ENG-PUDSP20001-R1-PUDSP-Redlines Summary_Markup Summary

SITE PLAN
P9 9 OF 10

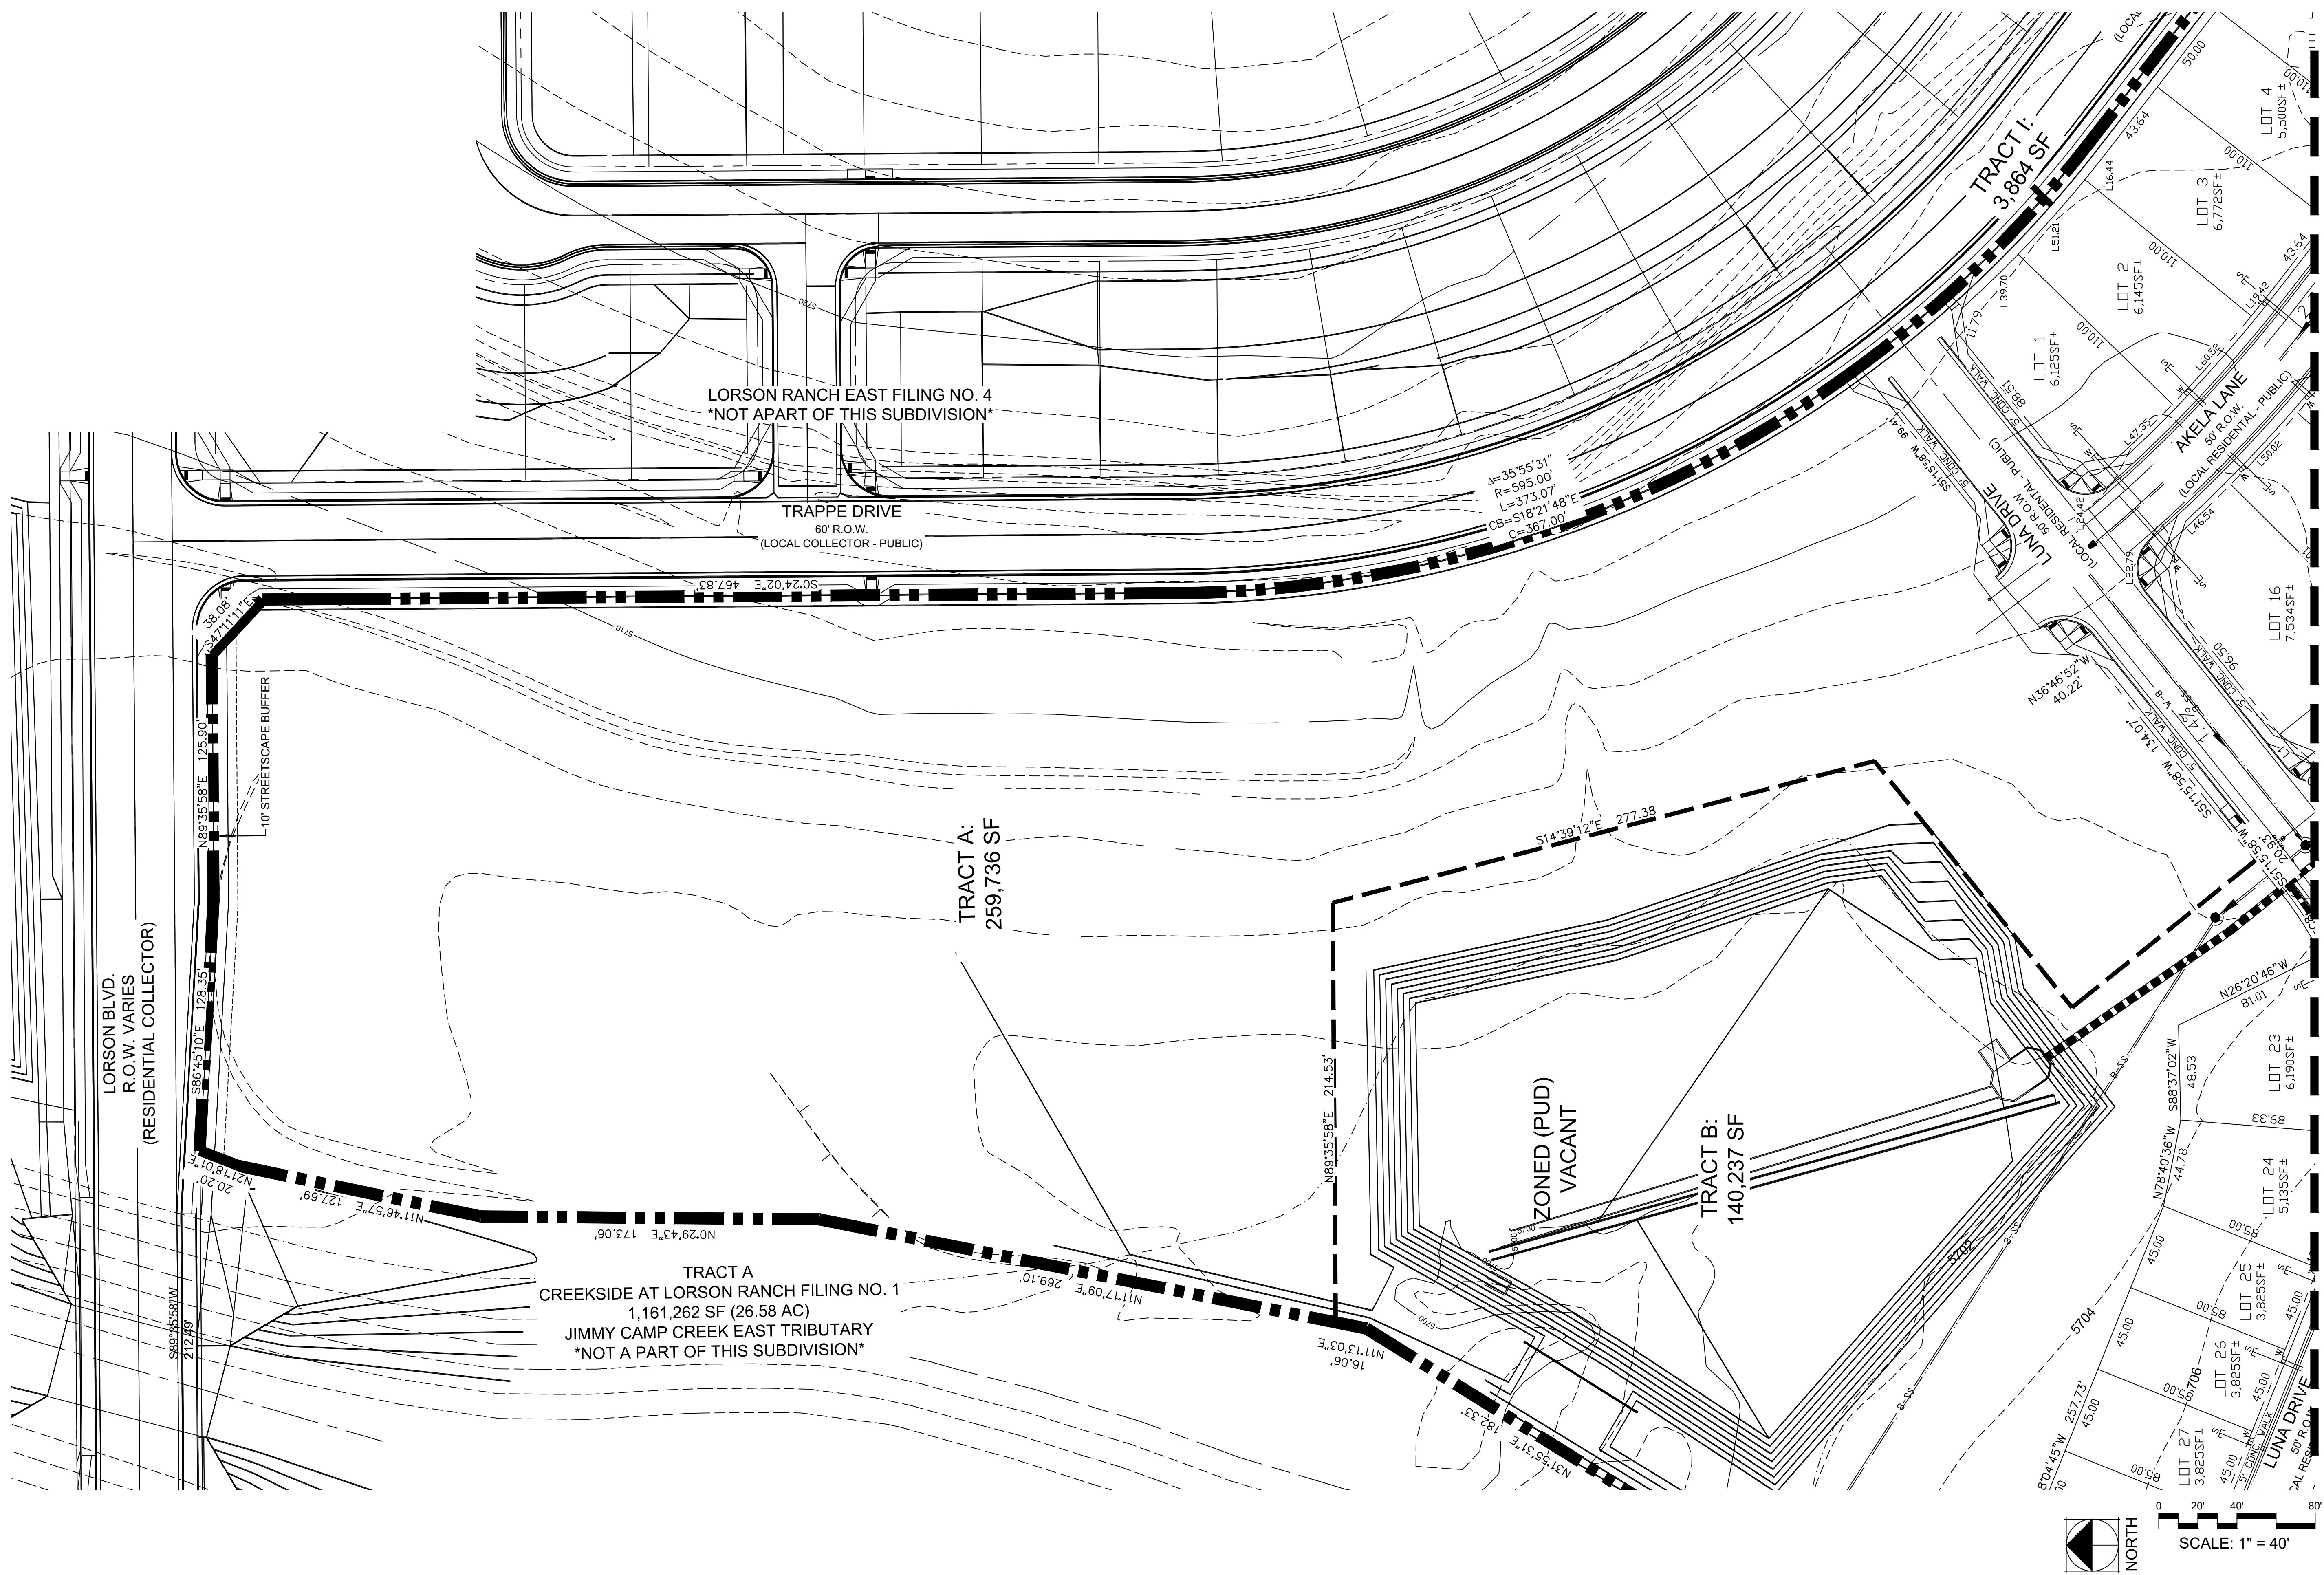
Outline and label ponding area

Label easement

show curb returns and ped crossing

lot lines need to be distinctive
